## Application for a Non-Material Amendment Following a Grant of Planning Permission

Construction of a single storey rear extension at 5 Helder Grove,  
SE12.

DC/23/131580

Change the flat roof with roof lights to a pitched roof with roof lights and tiles to match existing.

DATE: 2023.05.11  
 DRAWING No: P04 rev B  
 DRAWING TITLE: PROPOSED REAR ELEVATION  
 SCALE: 1:50 @ A3

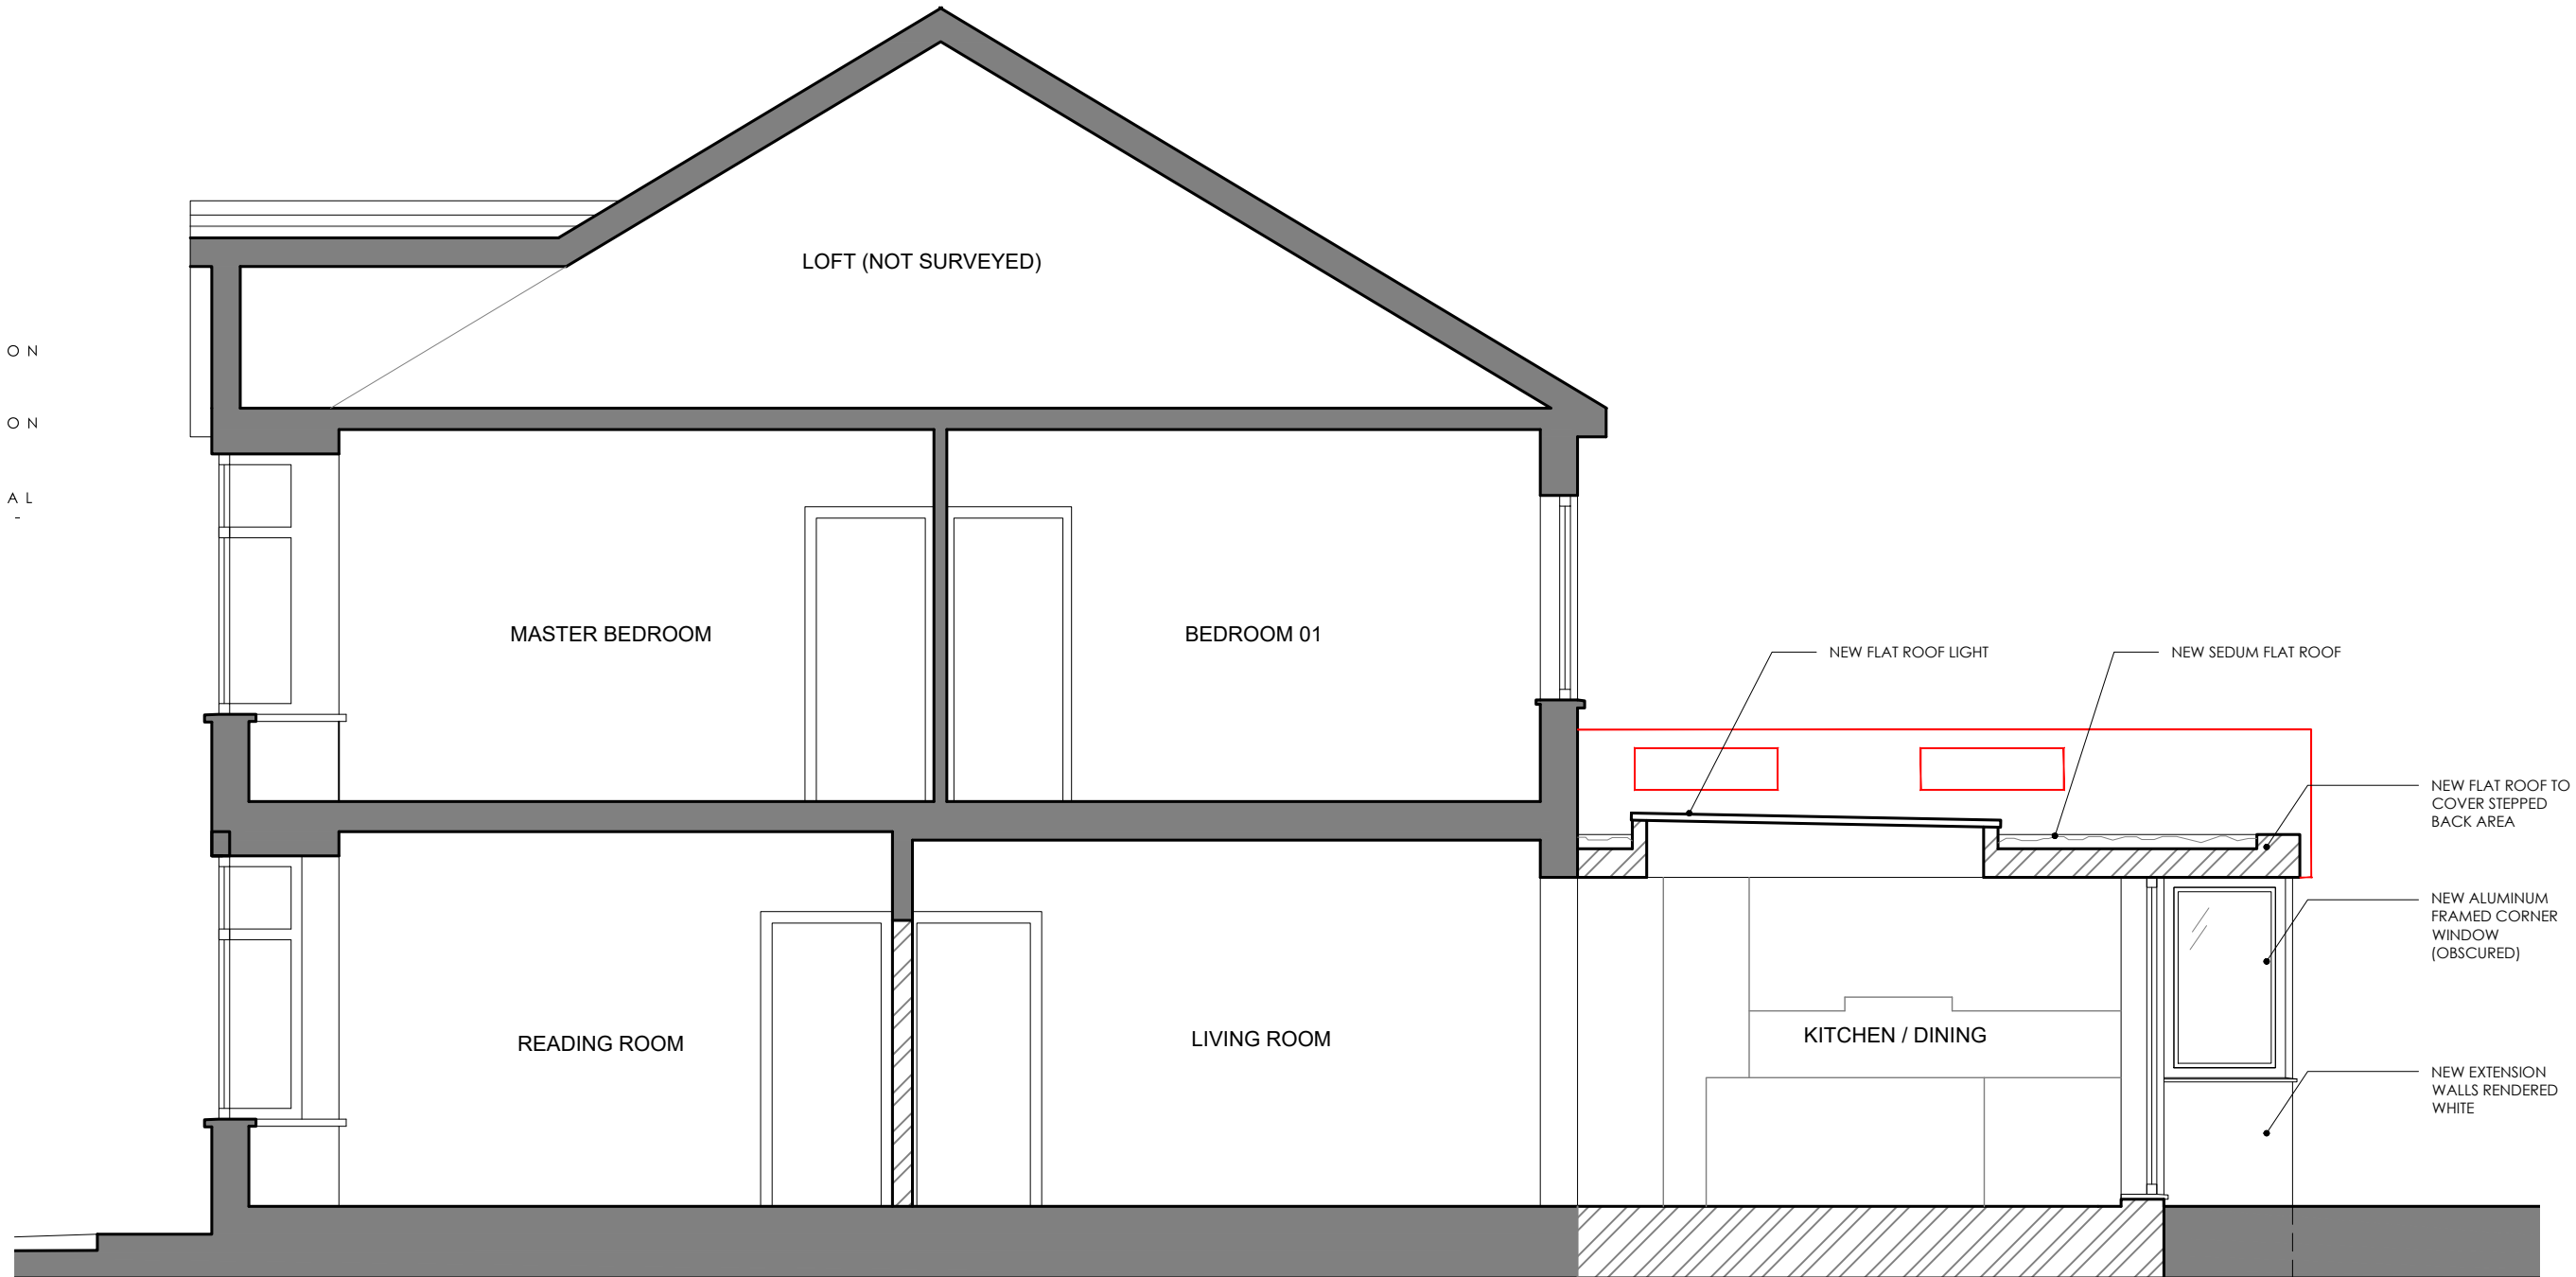
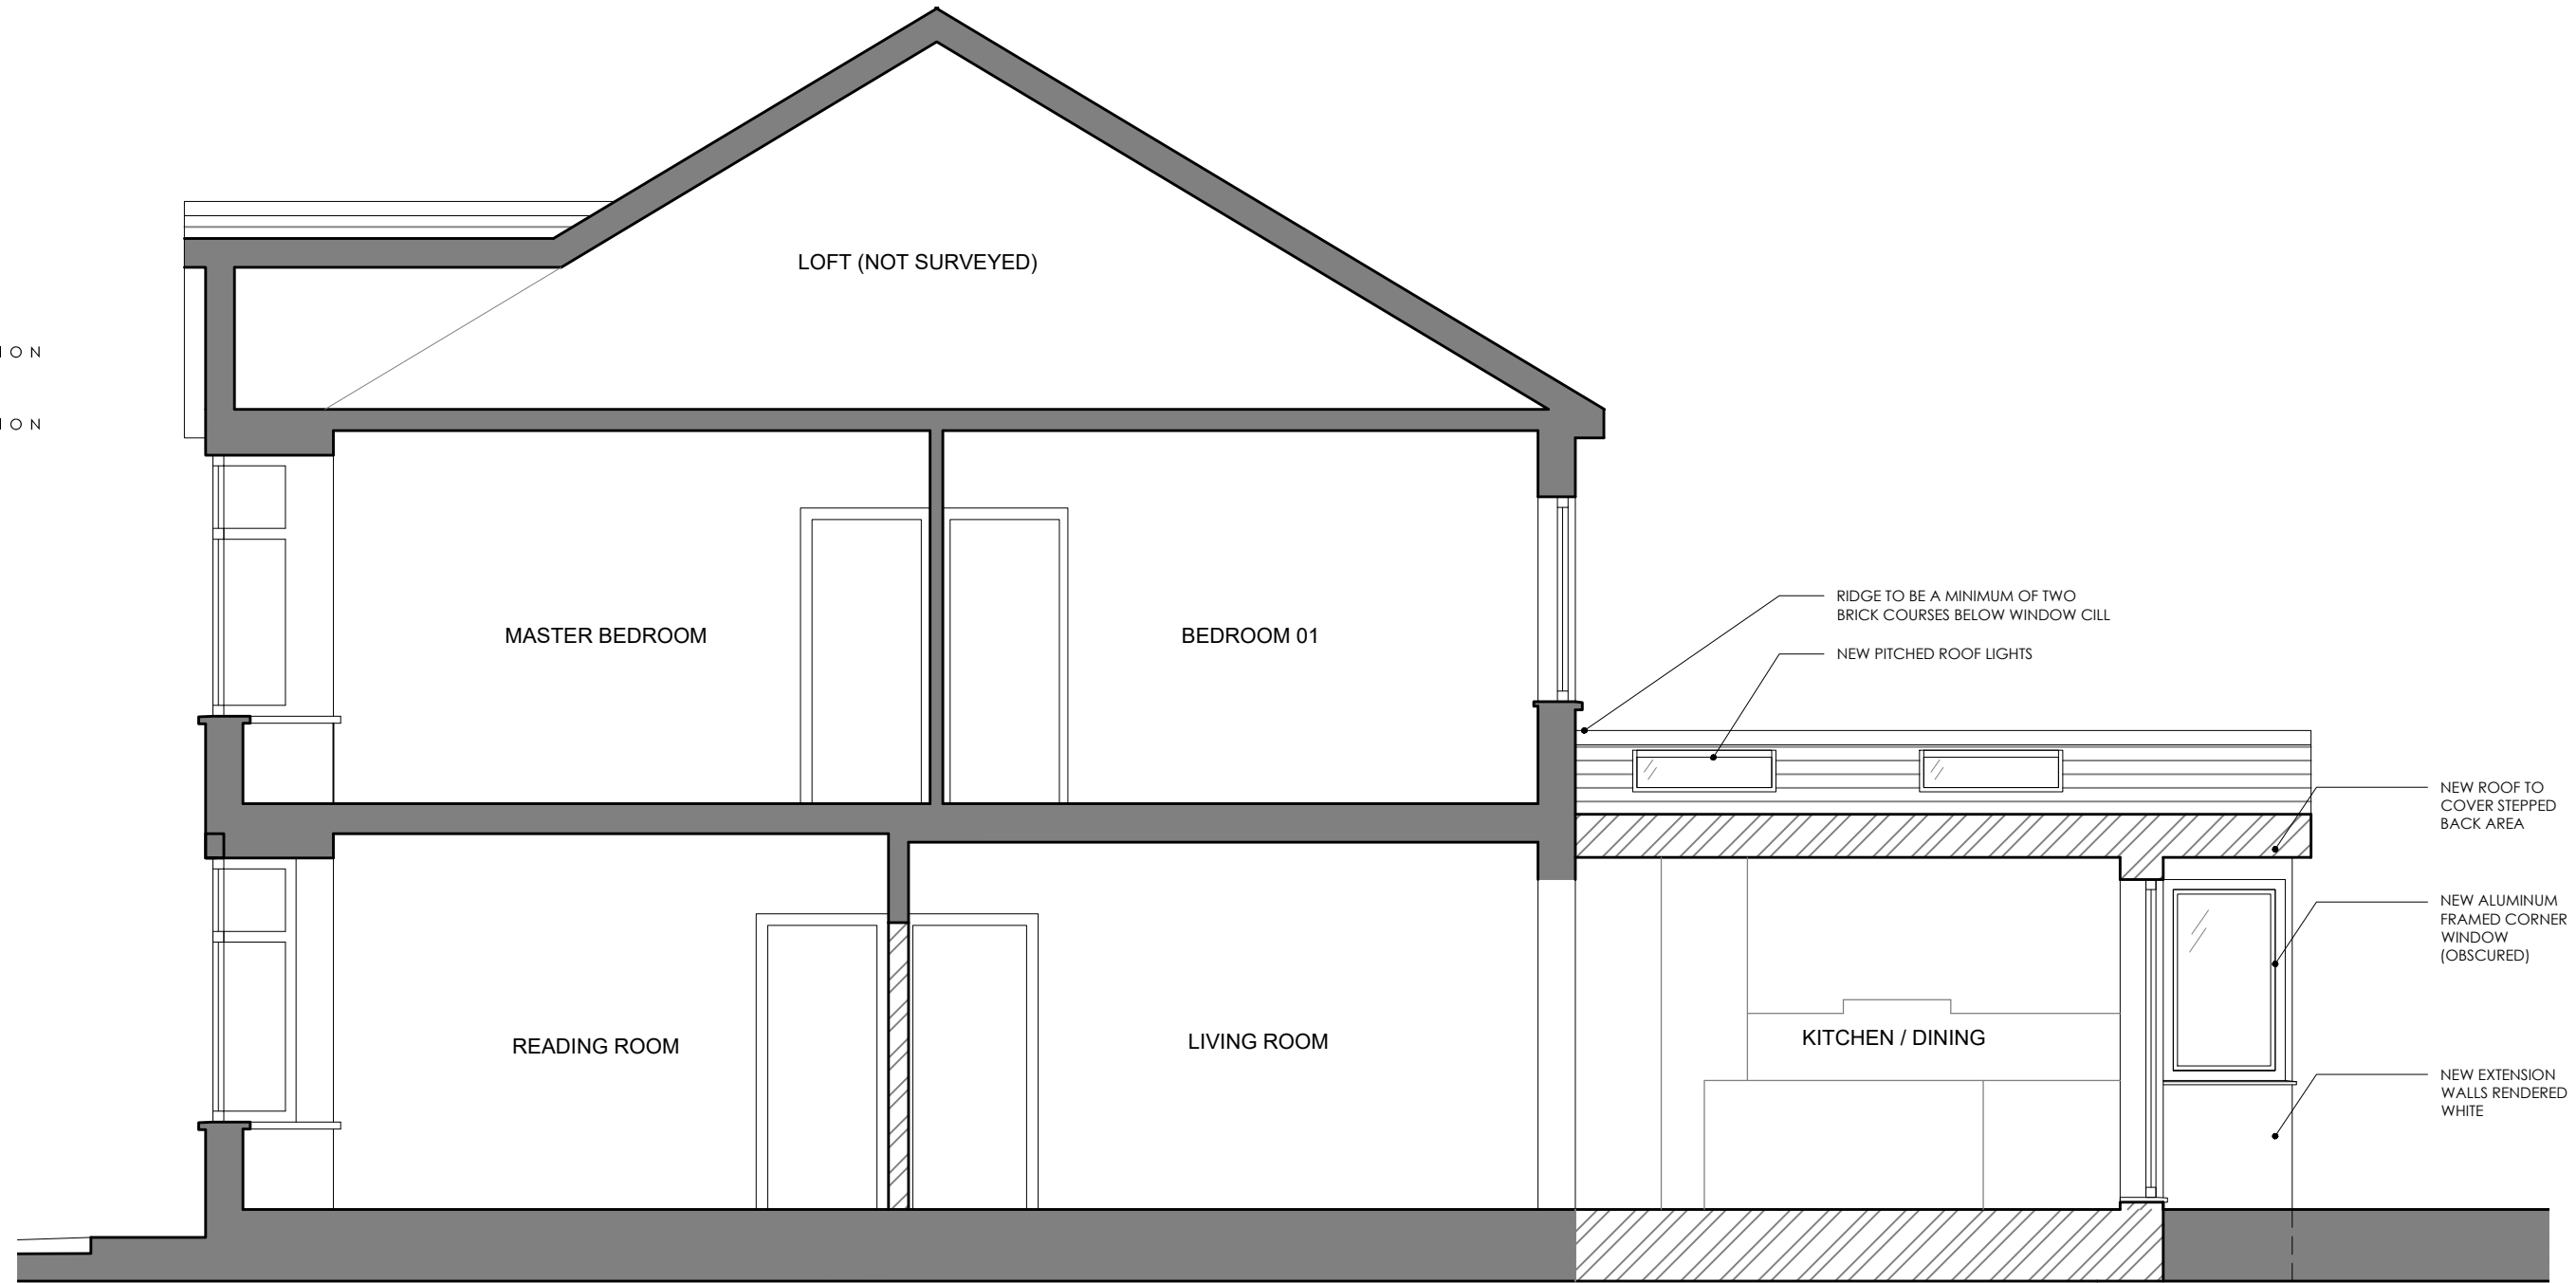
The internal head height achievable with the flat roof is too low for our Clients. Therefore we are seeking to change the flat roof to a pitched roof to achieve a more comfortable internal head height.
